CONSTRUCTION PLANS FOR CARRIAGE MEADOWS SOUTH AT LORSON RANCH

STREET, STORM SEWER, AND POND CONSTRUCTION PLANS

COVER SHEET
STREET, STORM SEWER AND POND
CONSTRUCTION PLANS

P:\100\100.030 const-street-stm-C1.3-TYPICALS.dwg Aug 28, 2017 - 2:44am

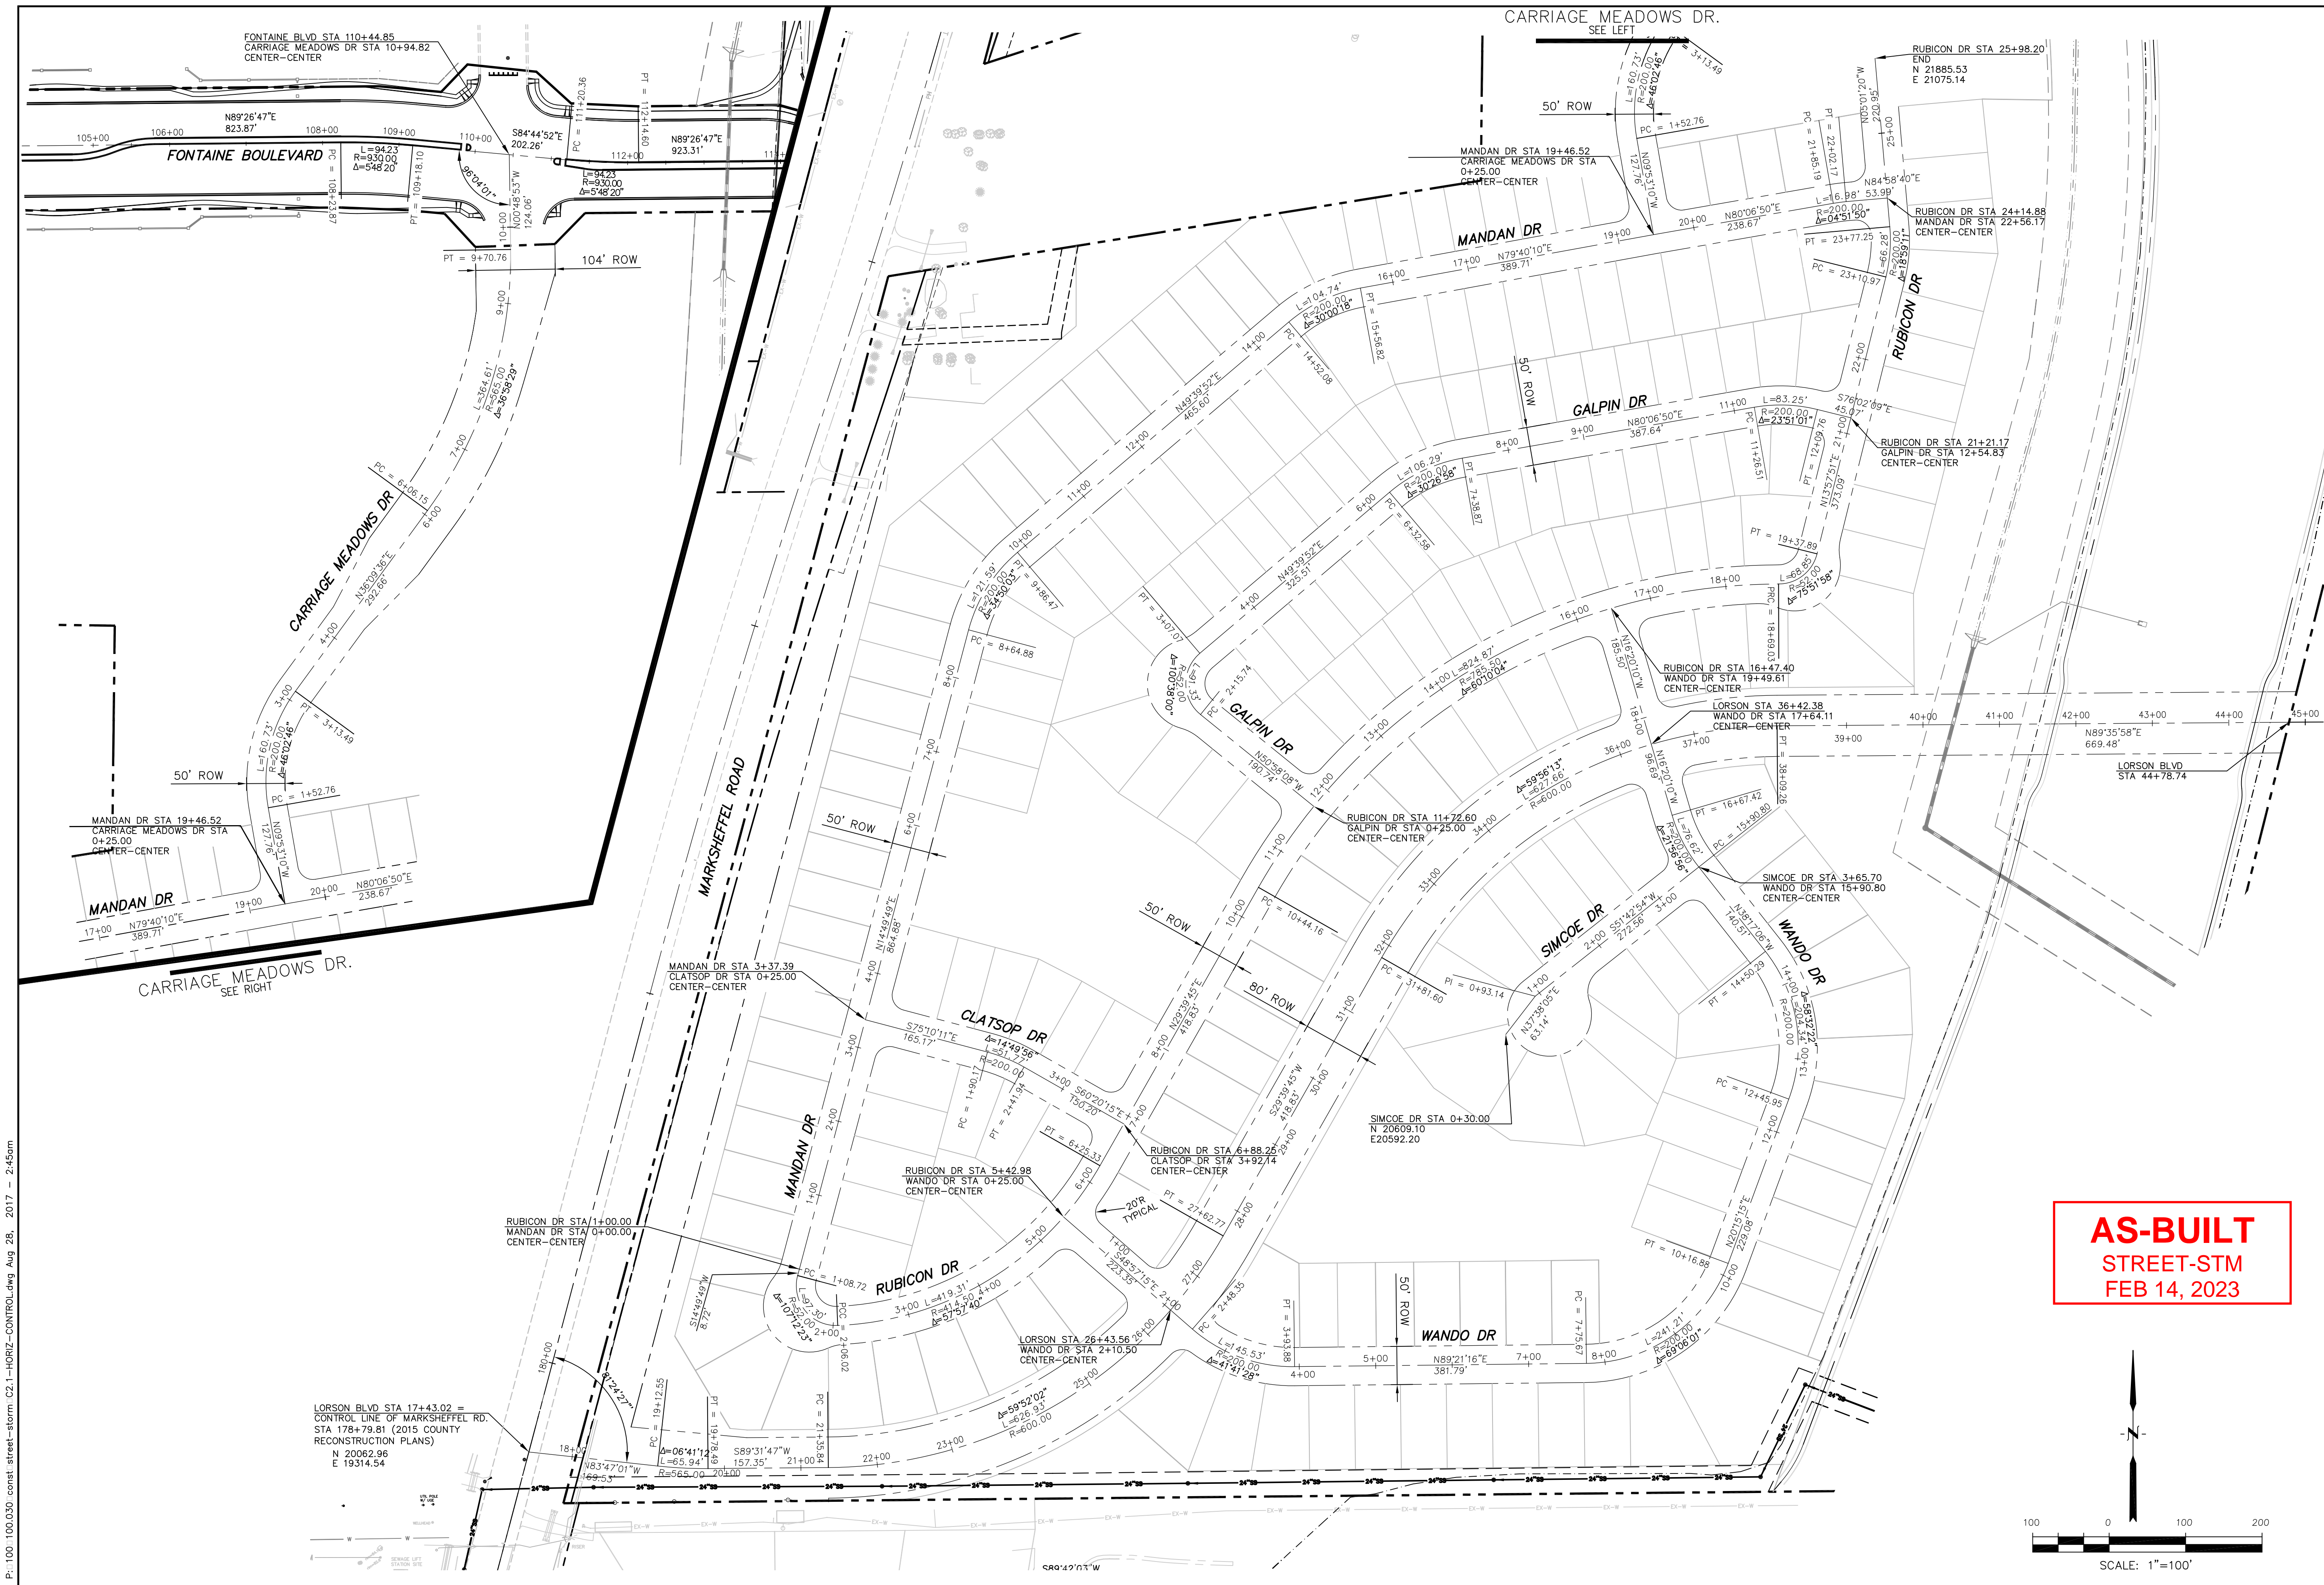
for better
performance,
please use
EPC optional
type C curb
and gutter per
SD 2-20.

please show
the anticipated
'ultimate'
condition

Please show cross section of Carriage
Meadows Drive just before the intersection
with Fontaine.

Please add
posted speed
and design
speed to this
document.

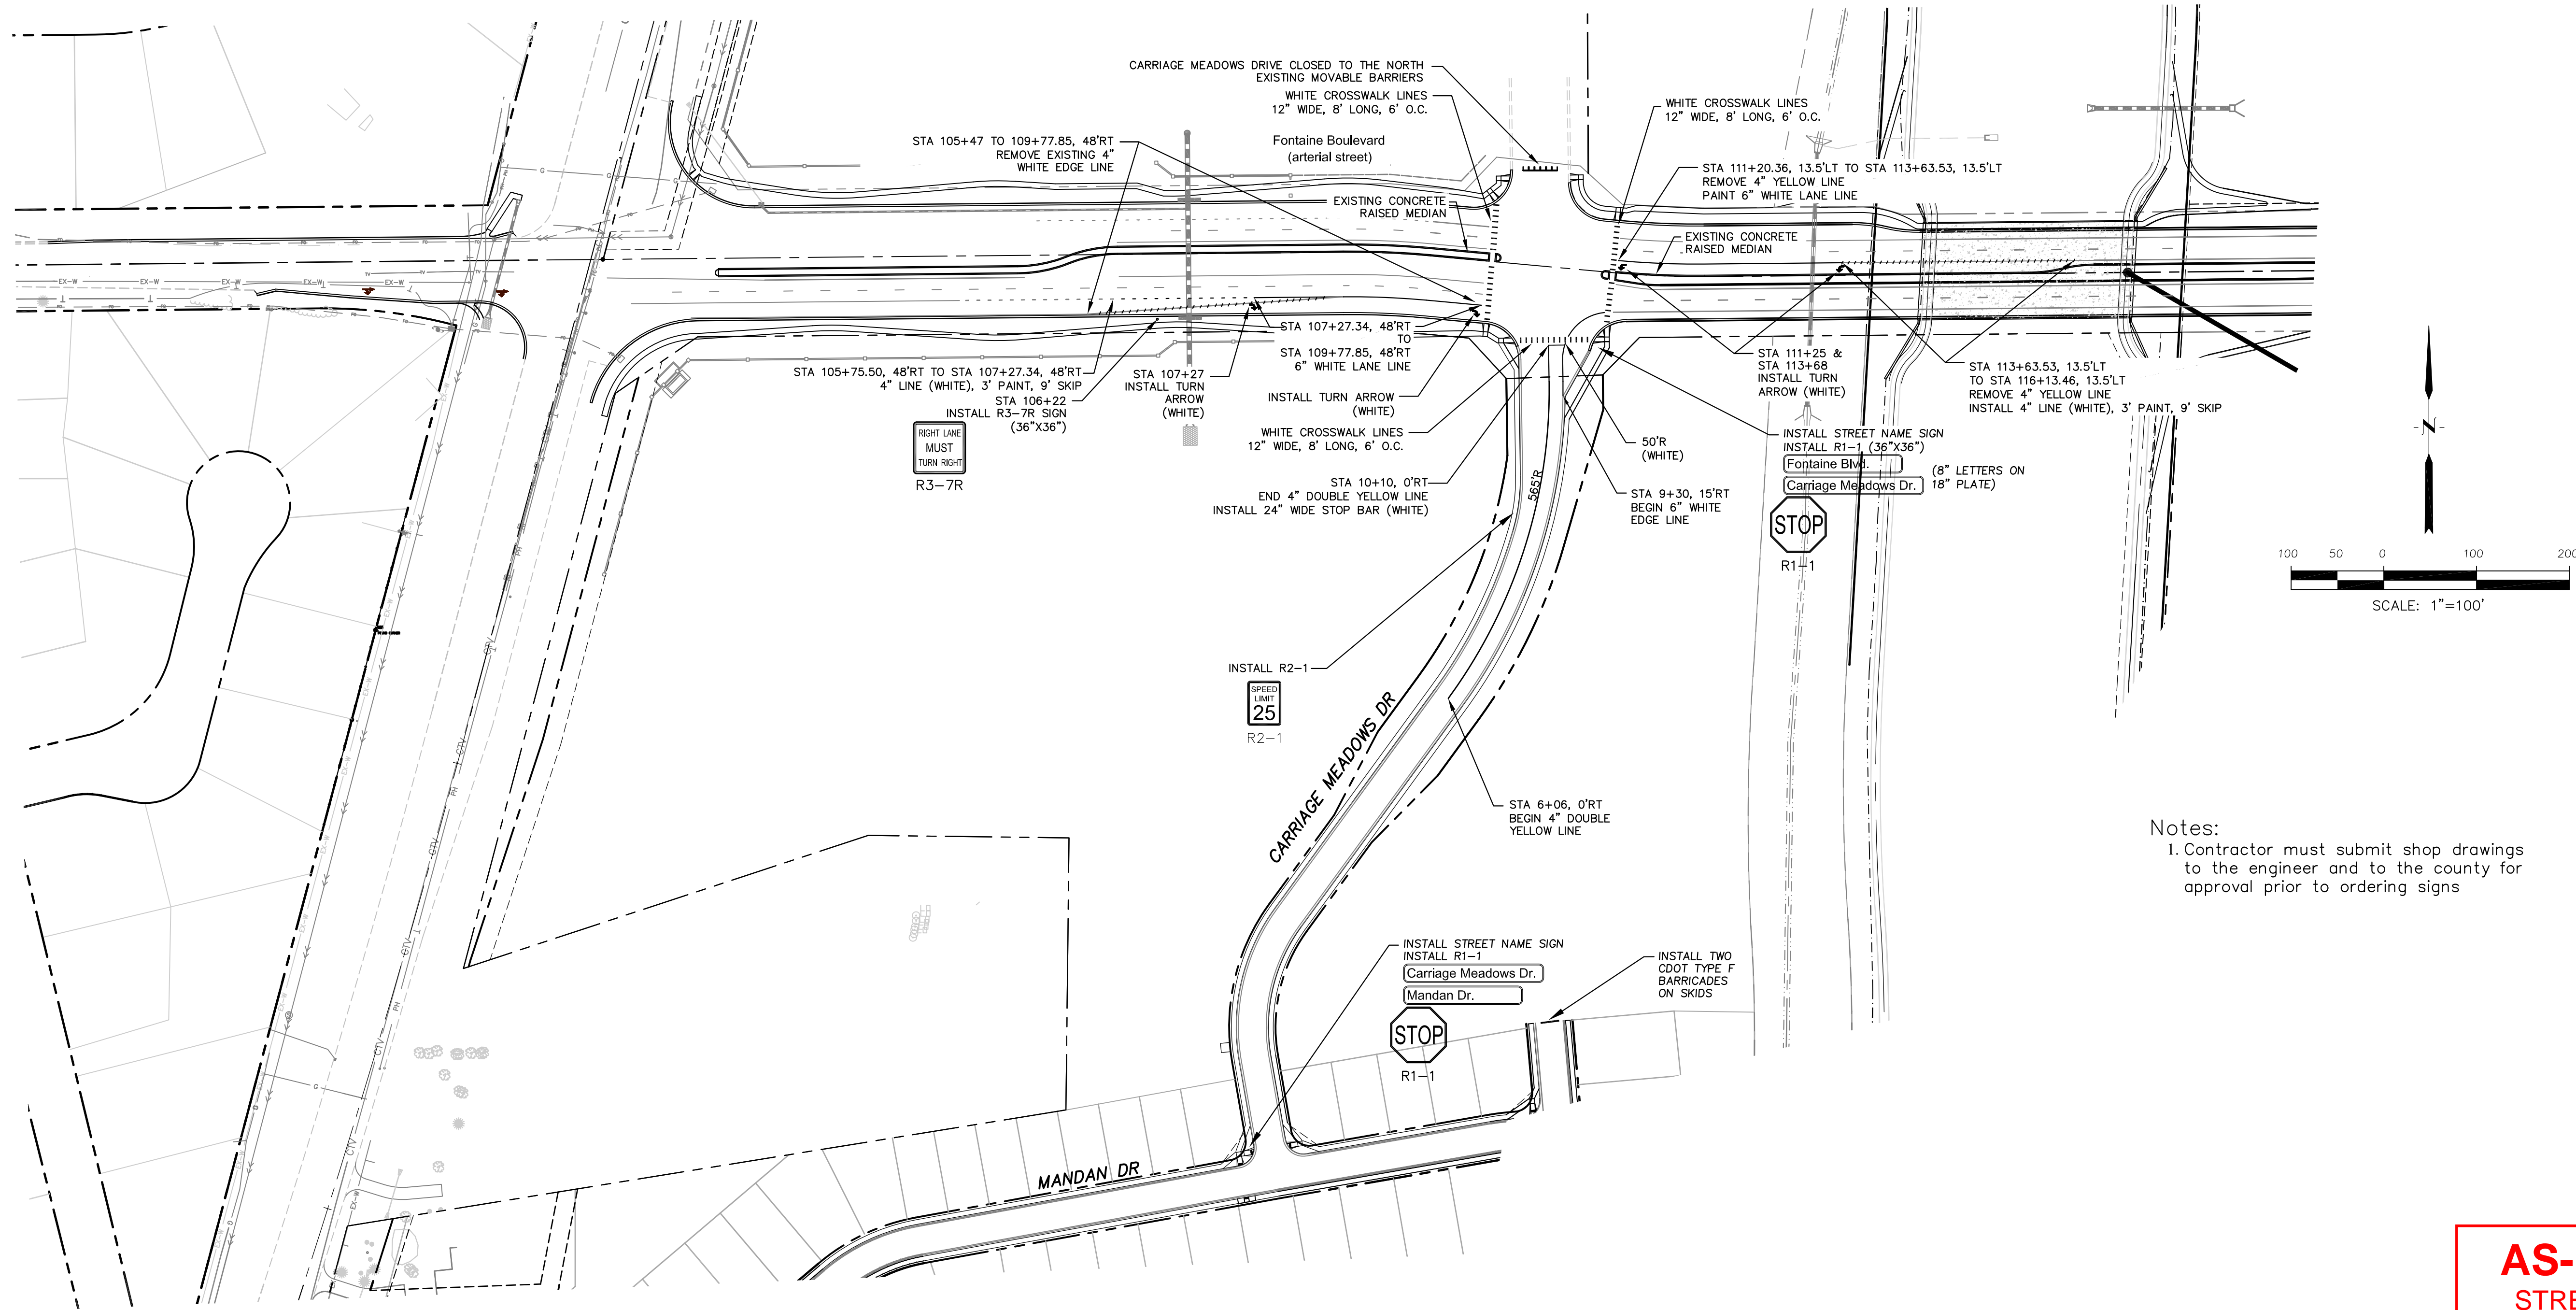
Please provide a legend for this and any appropriate sheet to show (at a minimum) proposed centerline, ROW, and property lines

Sight visibility triangles should be shown for all areas where lots may need to have landscape restrictions. Where landscape restrictions are required, a plat note will need to be added. some lots (may not be all inclusive) to look at are 137, 234, 216,8 (tract H), 12, and 13. Please place on individual PP sheets. this should also include intersections.

Please call out ROW for each proposed road similar to this.

**SIGNING AND STRIPING PLAN  
 FONTAINE BLVD &  
 CARRIAGE MEADOWS DR**

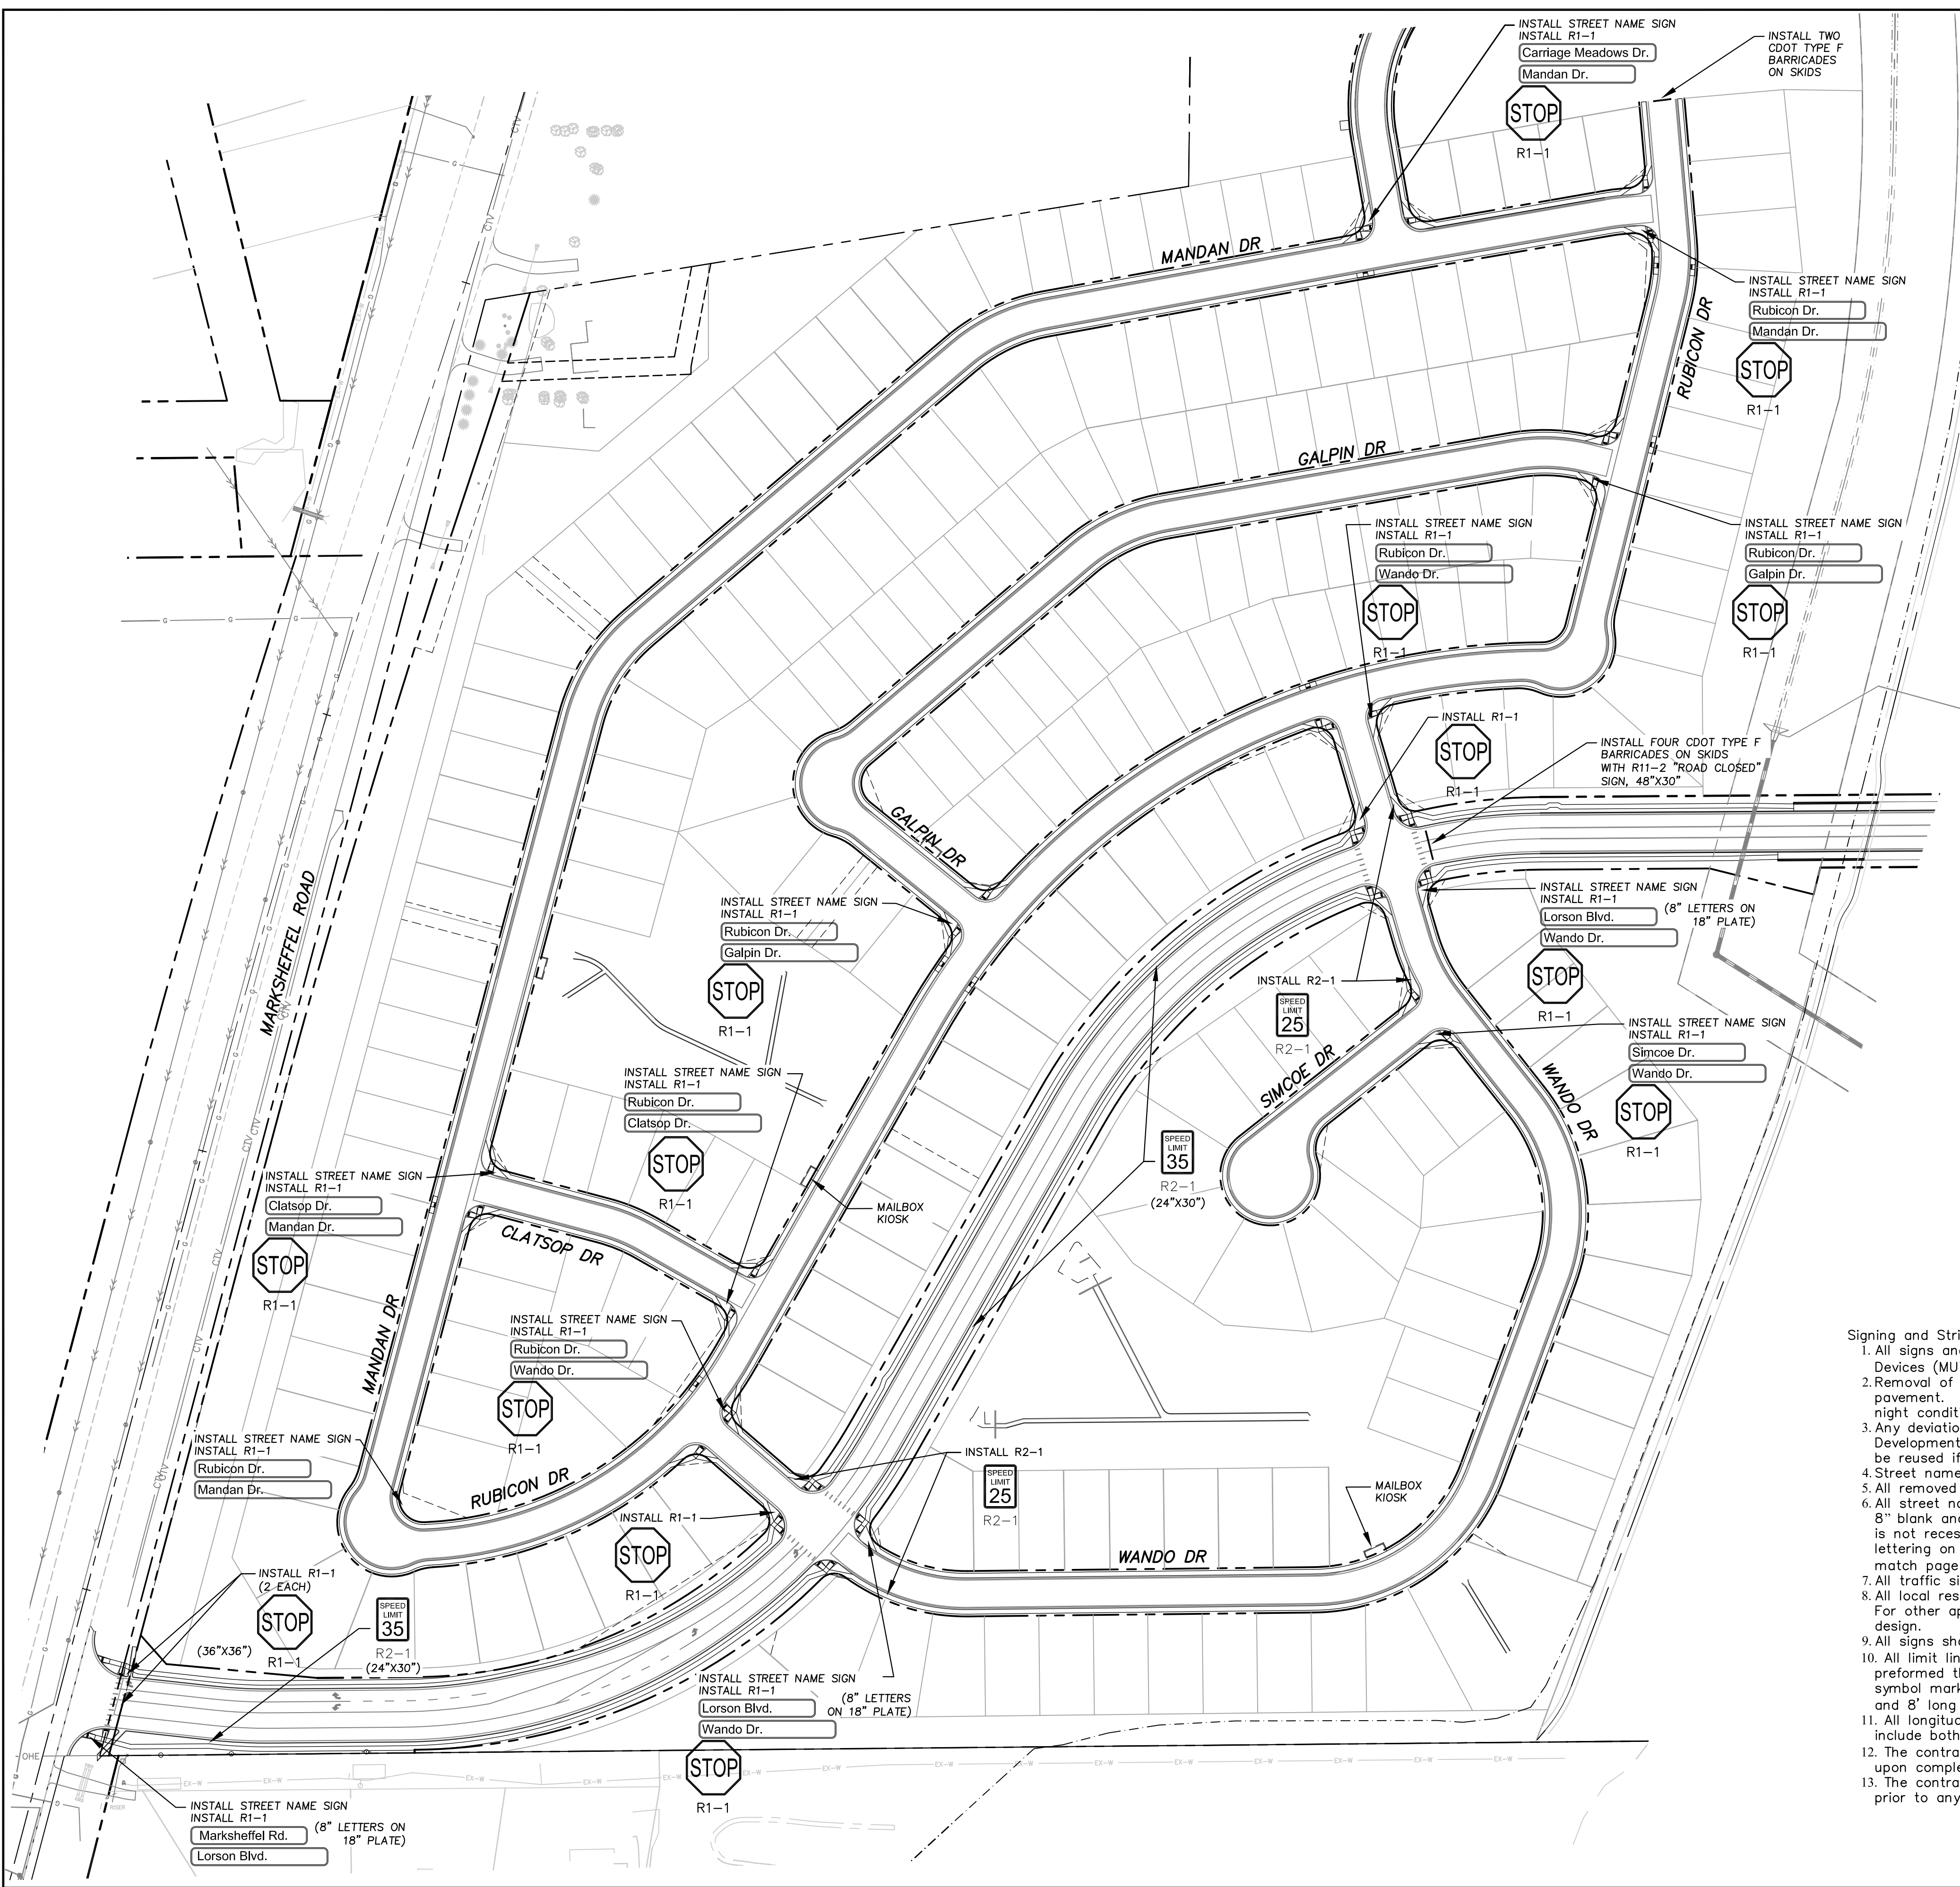
Please clarify that this street is not open at this time. and call out what barricade is existing

call out existing type median

Provide 36"X36"

A pedestrian refuge area is required at any location where the crossing length exceeds 48'

provide 36"X36" sign

please call out appropriate end of road signage at this location.
